From: Simon Davis
Sent: 25 February 2019 10:49
To: Planning.Responses
Subject: FW: BR/273/18/PL - The Gables Hotel, 28 Crescent Road, Bognor Regis, PO21 1QG

From: Kate Giddings
Sent: 21 February 2019 16:46
To: Simon Davis
Cc: Anna Appleton
Subject: BR/273/18/PL - The Gables Hotel, 28 Crescent Road, Bognor Regis, PO21 1QG

In relation to the above application, please may EH make the following comments:

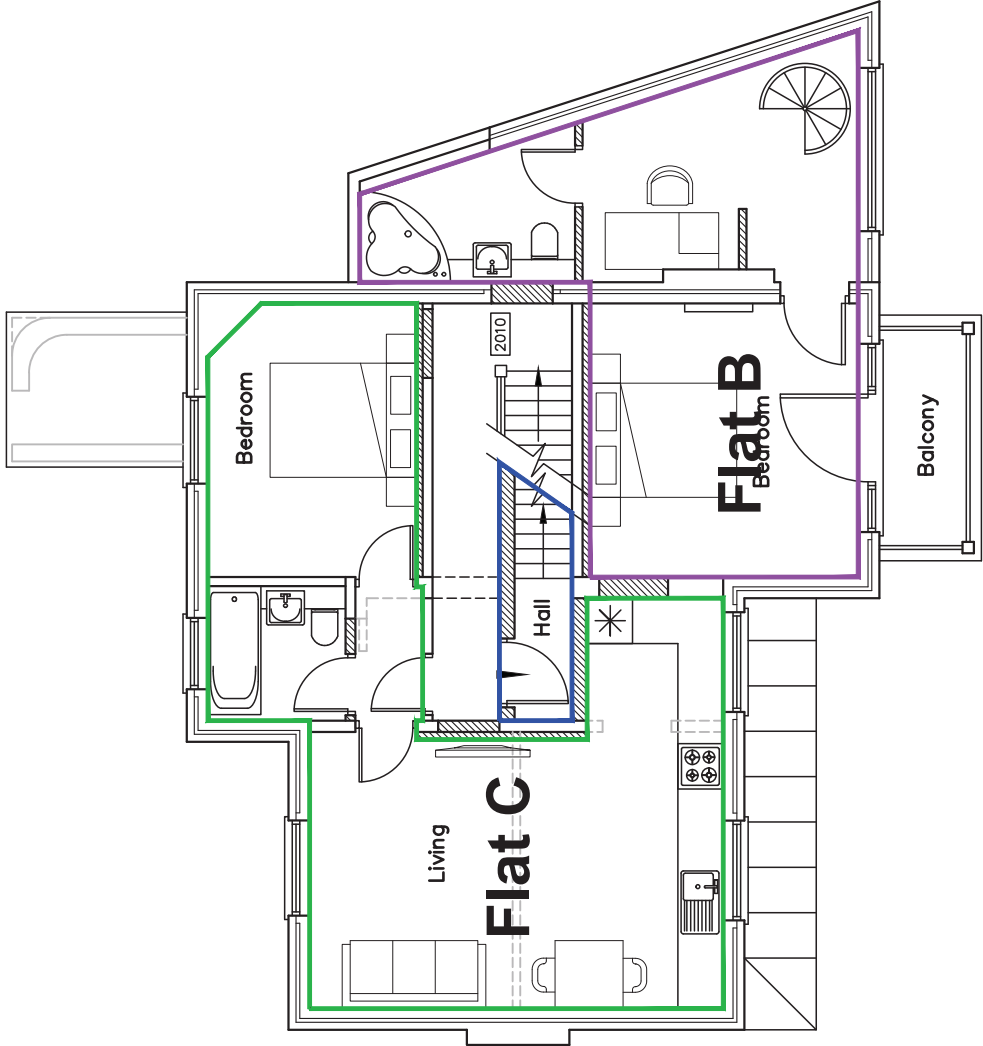
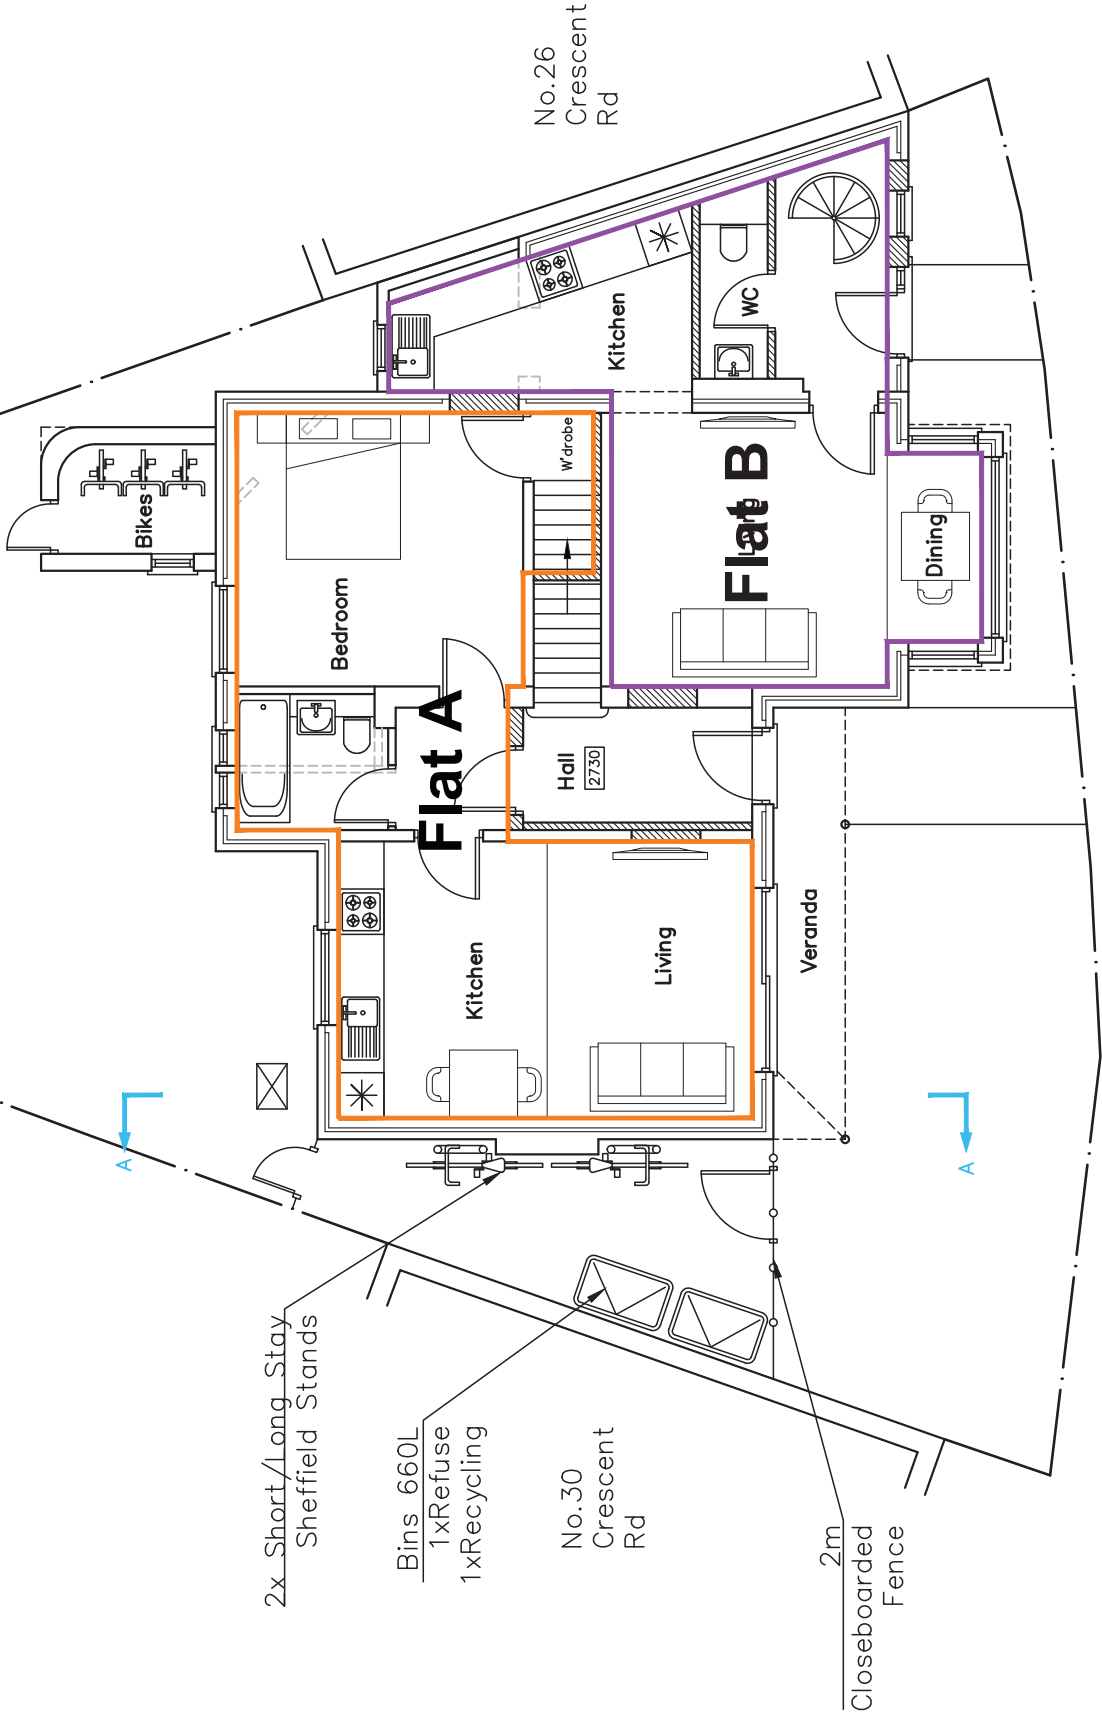
- Appropriate sound insulation should be installed between the flats, with particular attention being paid between the bedroom of Flat C and the bathroom of Flat D (although I am sure this will be addressed by Building Control).
